CITY OF ALBUQUERQUE

August 3, 2023

Re: Burger King
880 Juan Tabo Blvd. NE
30-Day Temporary Certificate of Occupancy
Transportation Development Final Inspection
Architect's Stamp dated 11-23-20 (K22-D035B)
Certification dated 07-26-23

### TRAFFIC CIRCULATION LAYOUT

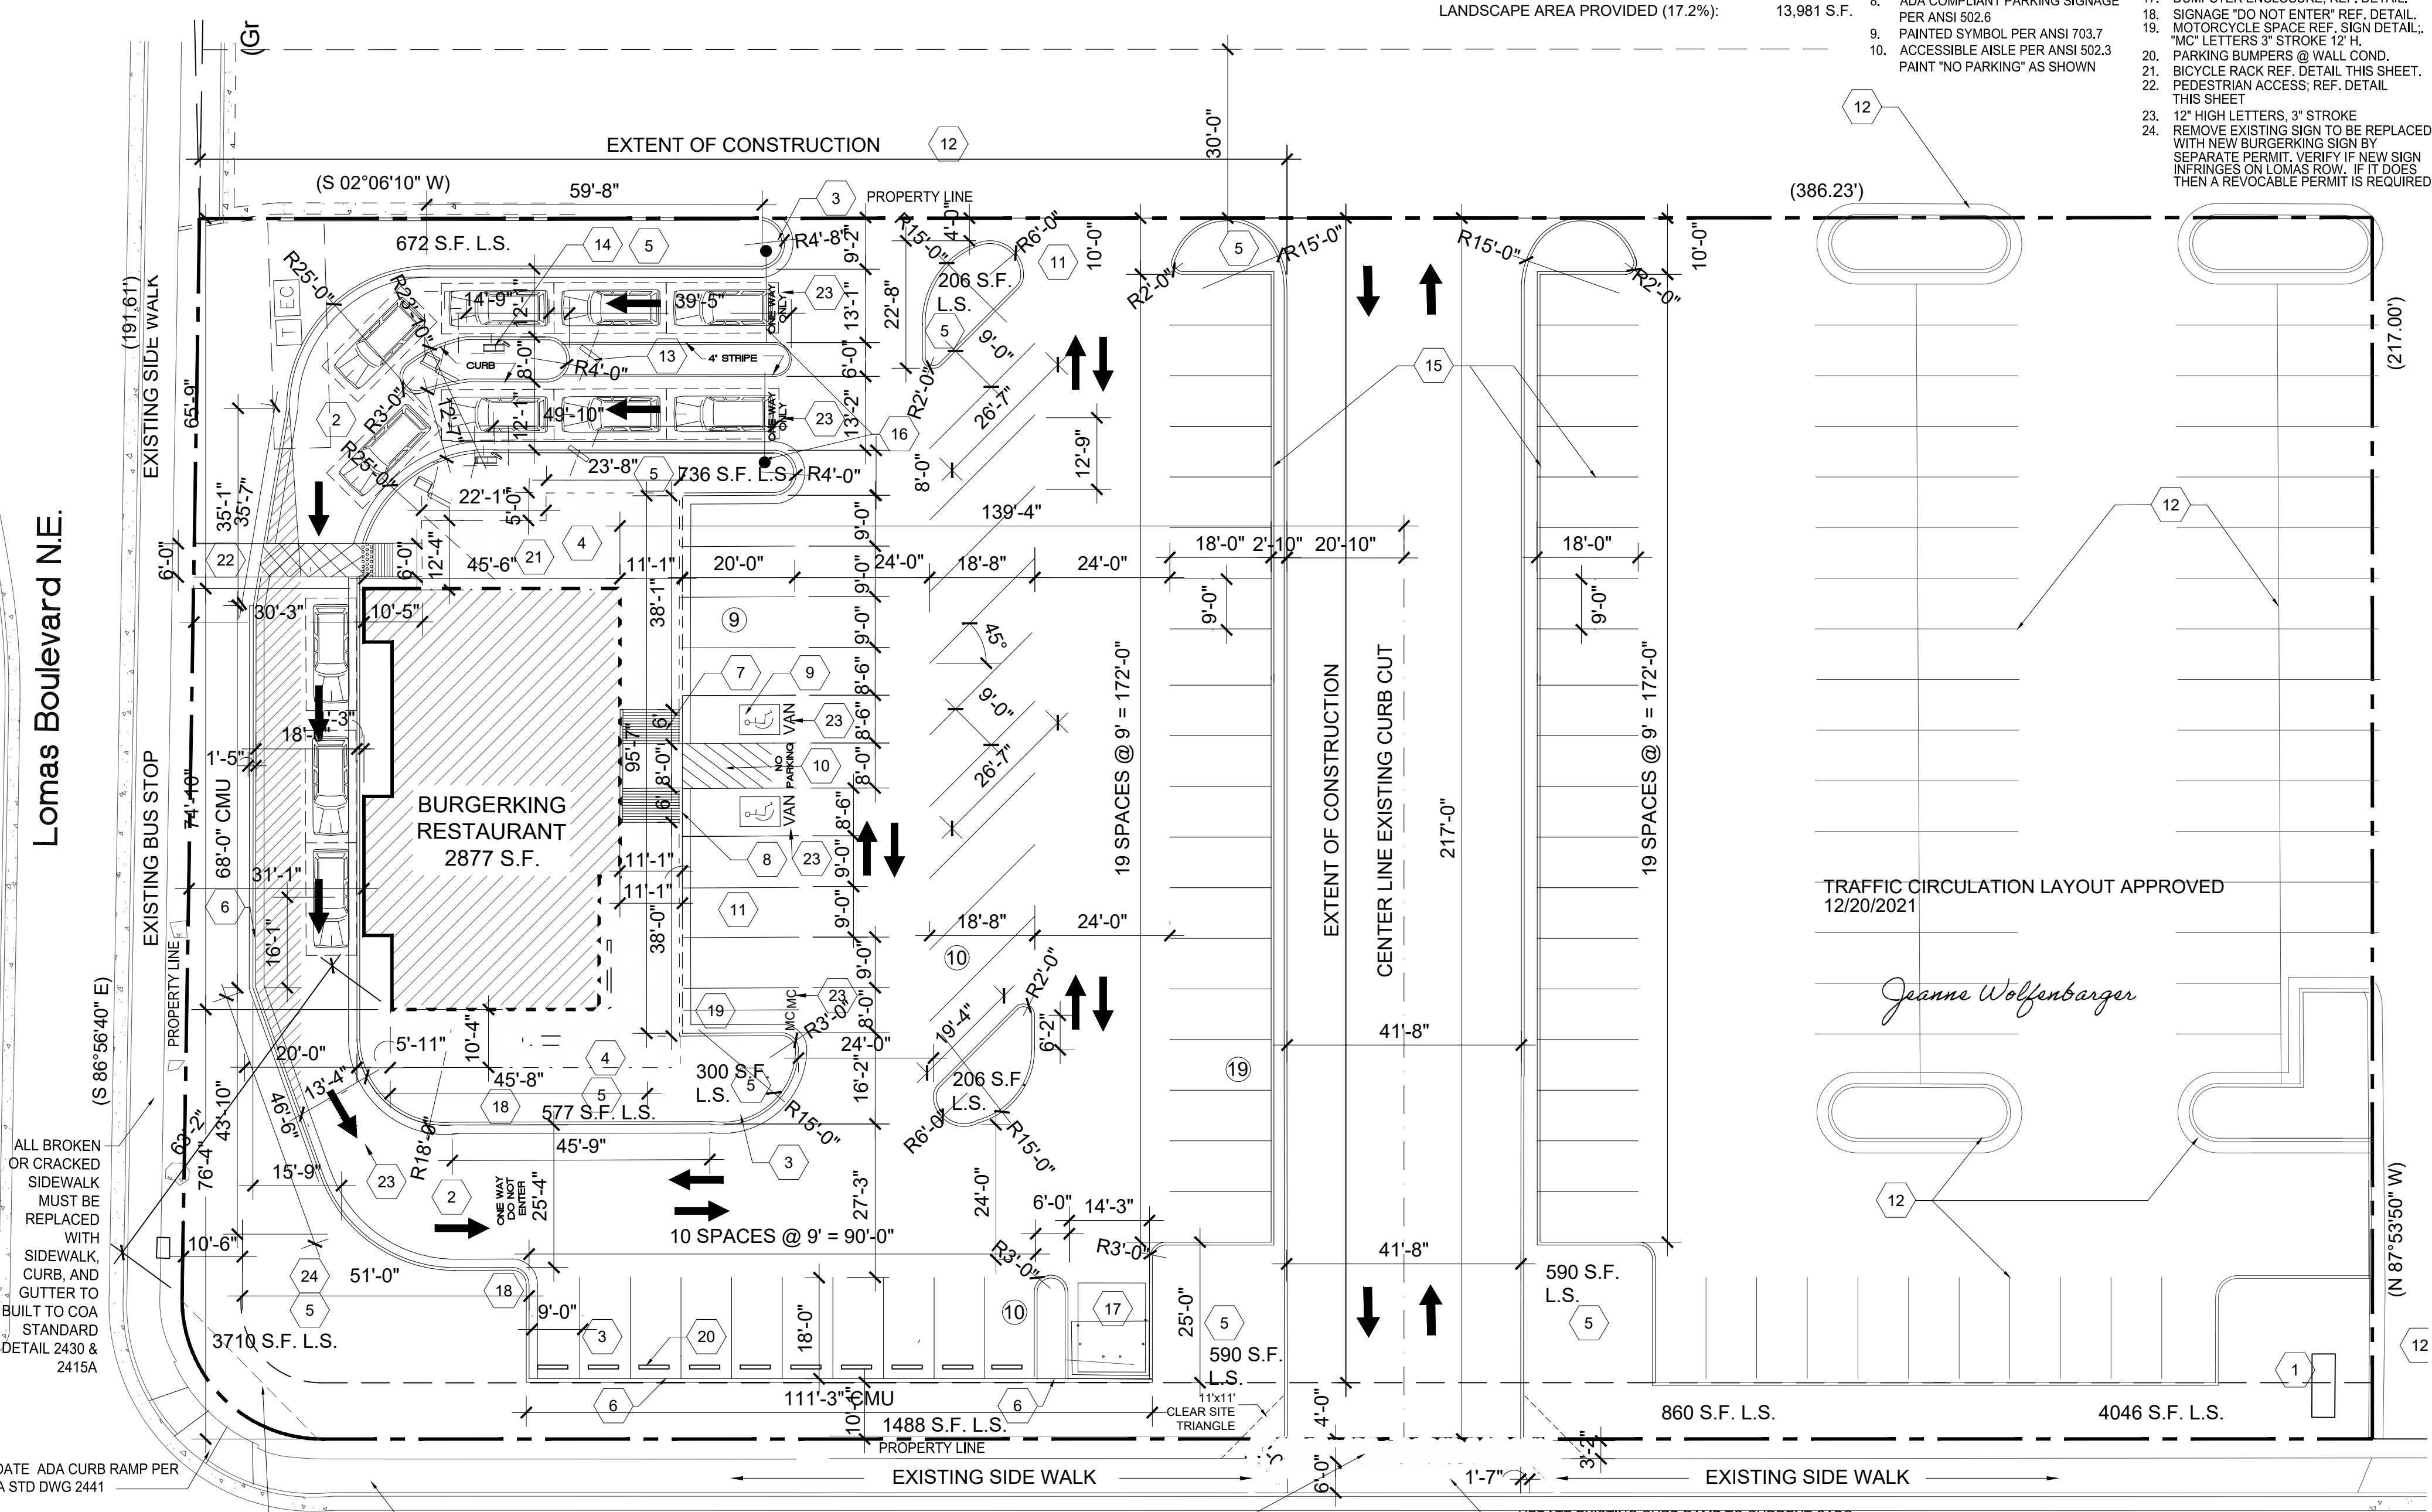
- Drive aisles: Please modify the directional pavement marking arrows, to allow efficient movement with a logical pattern that the driver can easily understand and follow.

- Per site visit the MC parking space width was 3.5'. Minimum MC stall width should be 4'.
- Per the approved plan, please provide hoop Bike Rack, ribbon bike rack is no longer permitted in the city.
- Please finish the paving work on the driveway.
